Midlothian Council

Application for Detailed Planning Permission: Extension to dwellinghouse and external alterations including alteration to window opening to form door at 22 Broomieknowe, Lasswade, EH18 1LN

Your Ref:
Our Ref: 21/00888/DPP

Proposed Roof Plan  
Scale - 1:100

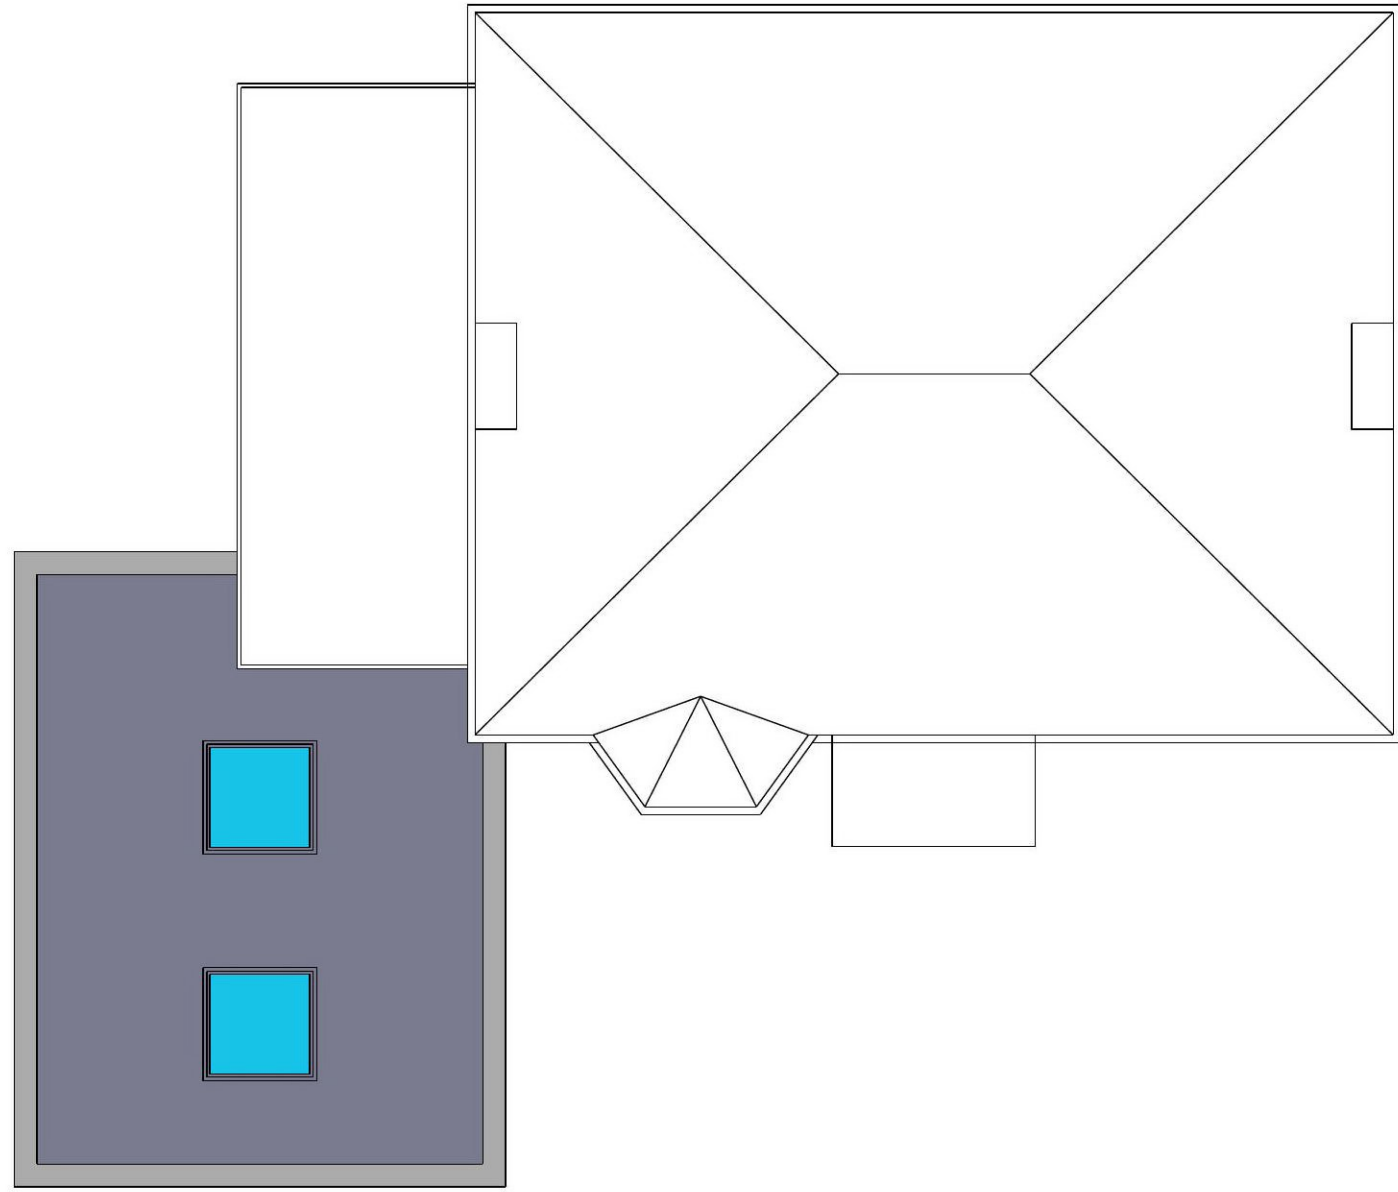
Insufficient drawings have been submitted. Please forward the following drawing:

- Please submit a proposed roof plan.
